Please could you supersede the previous versions and add the attached revised plans to the case file as follows:

Proposed Site Plan (2.01 A)

Site Location and Block Plan and Street Scene Elevation (2.05 A)

Re: Development at 58 Ferringham Lane, Ferring
Your ref: FG/41/20/PL

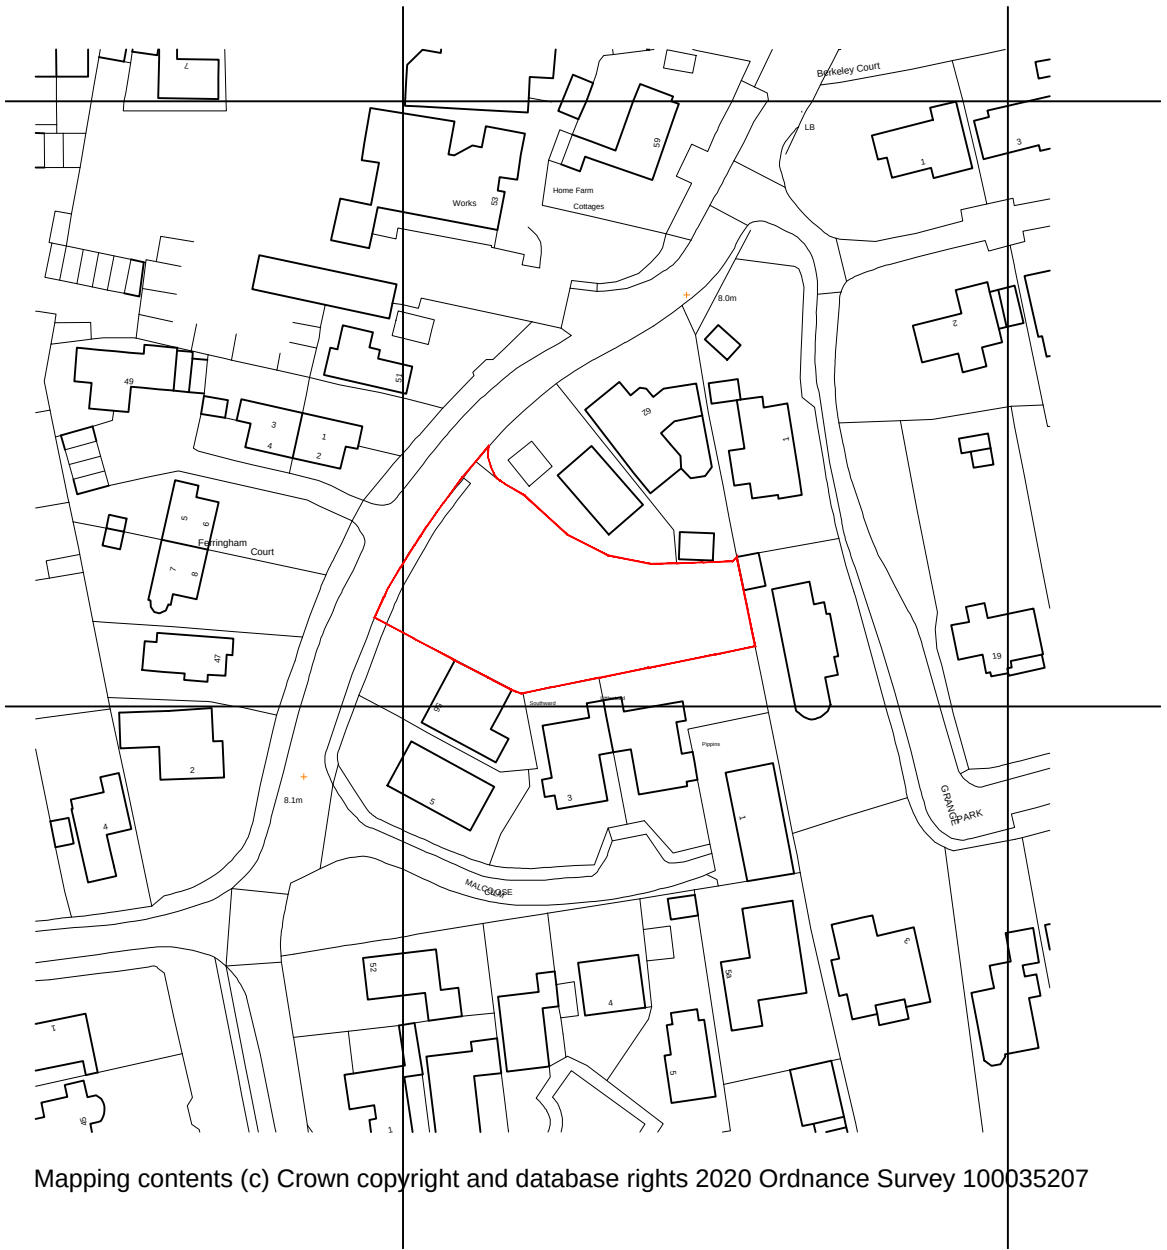
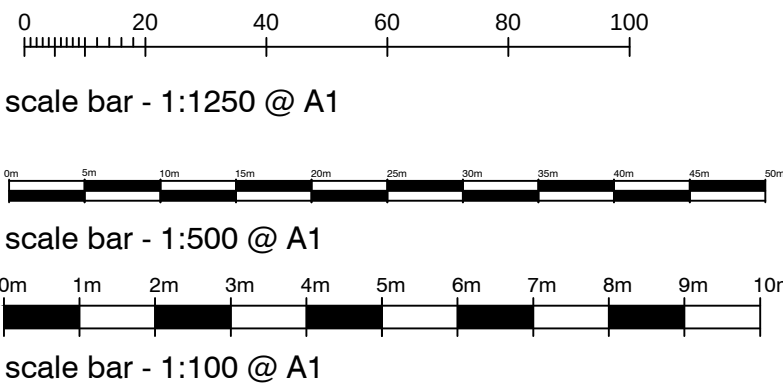
In summary, in relation to point 2, the front wall – we were unaware of the owners previous agreements with the previous land owners and the applicant is happy to continue this agreement, and as such we have amended the drawings, ref: 201A and 2.05A, as attached, to reflect the proposed brickwork wall to the street frontage being 1.0m in height, a reduction of 200mm to assist with the neighbours visibility from their driveway.
